**Re : Railway (Metrolink–Estuary to Charlemont via Dublin Airport) Order 2022
Aercap House (former 65-68 St. Stephens Green)**

This submission has been prepared by Waterman Moylan on behalf of Hines Real Estate Ireland Limited, who are the owners of the existing commercial building located at Aercap House (former 65-68 St. Stephens Green).

The properties are located in the City Centre between MetroLink Chainage 18+600 and Chainage 18+700.

### Figure 14.2 Groundborne Noise from Tunnel Boring Machine Sheet 7 of 7

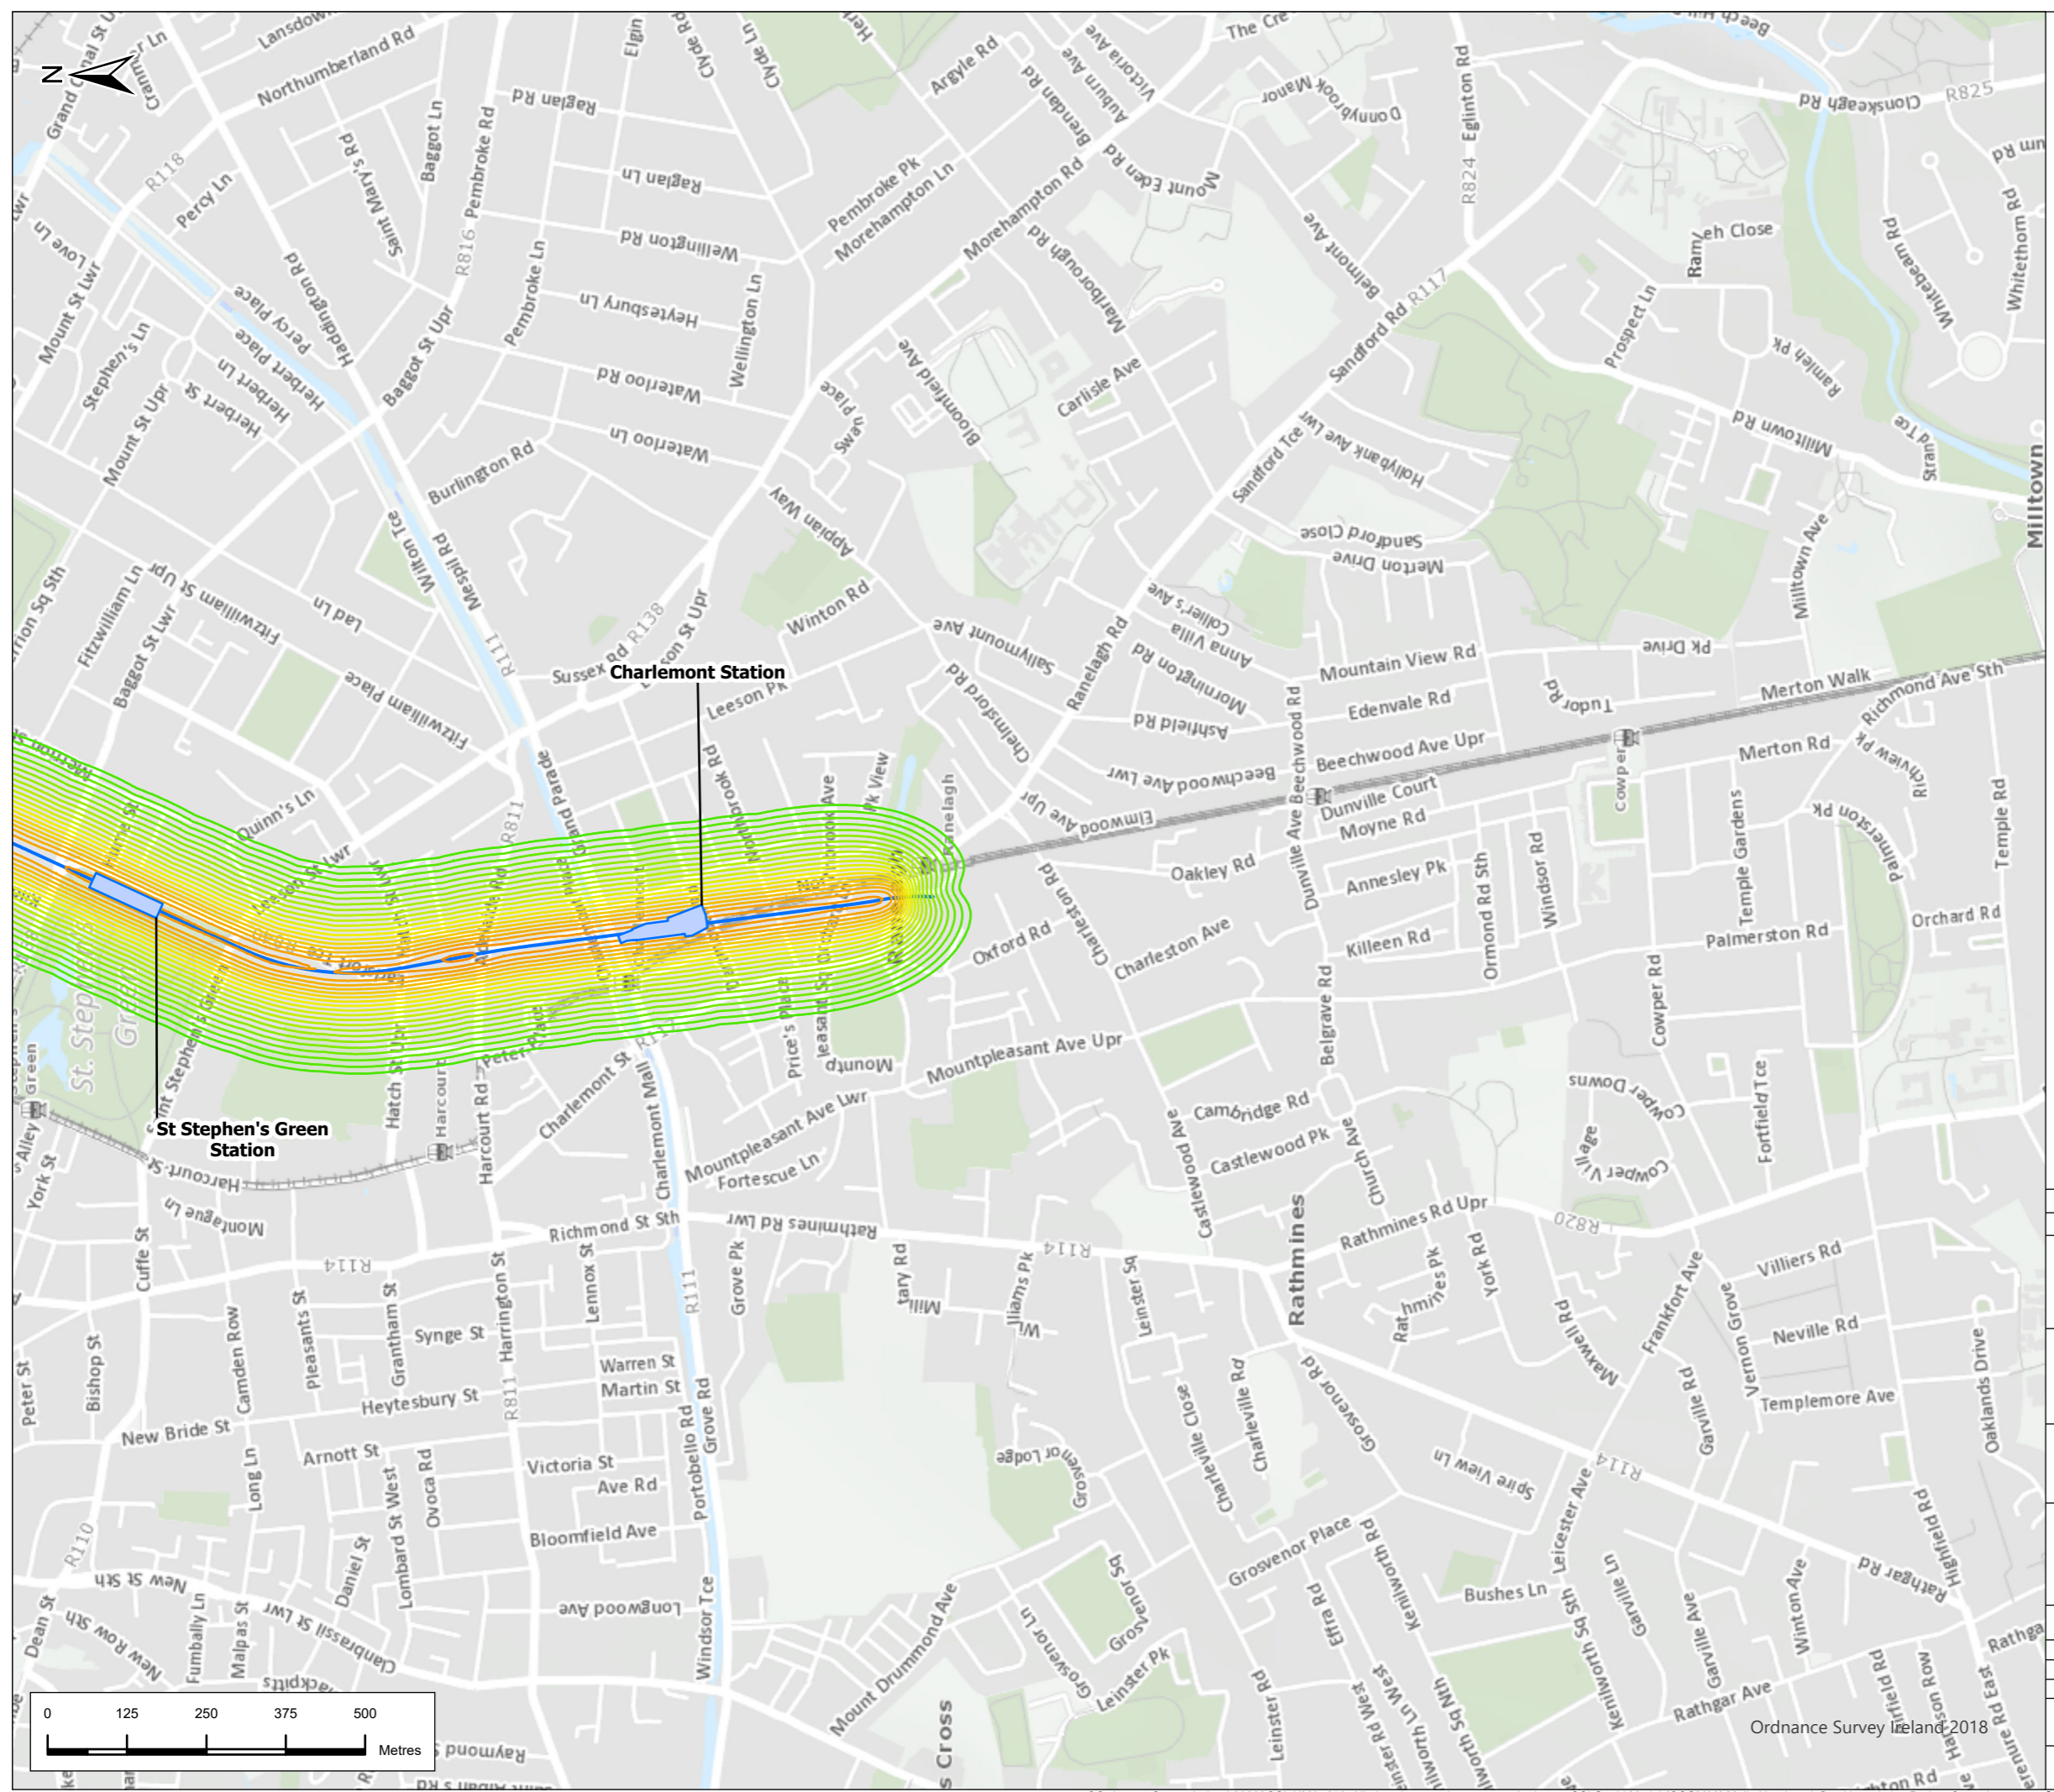
- a) Metrolink has assessed the "Groundborne Noise from Tunnel Boring Machine" and presents its findings on drawing no. ML1-JAI-EIA-ROUT-XX-DR-Y-14009 (a copy is attached to this submission). This drawing indicates MetroLink will generate an additional 50db directly under the location of our client's building which is unacceptable.

Drawing Title
Figure 14.6 Groundborne Noise from Operation
 Sheet 7 of 7

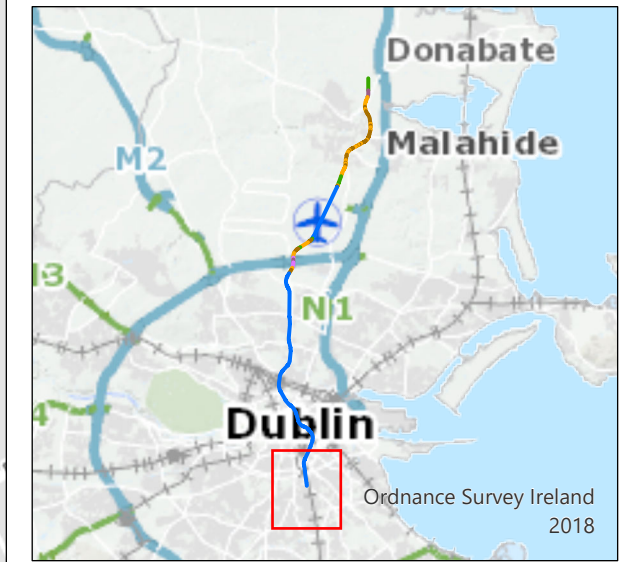
- a) Metrolink has assessed the "*Groundborne Noise from Operation*" and presented its findings on drawing no. ML1-JAI-EIA-ROUT-XX-DR-Y-14041 (a copy is attached to this submission). This drawing indicates MetroLink will be generating an additional 30db directly under the location of our Clients building which is unacceptable.
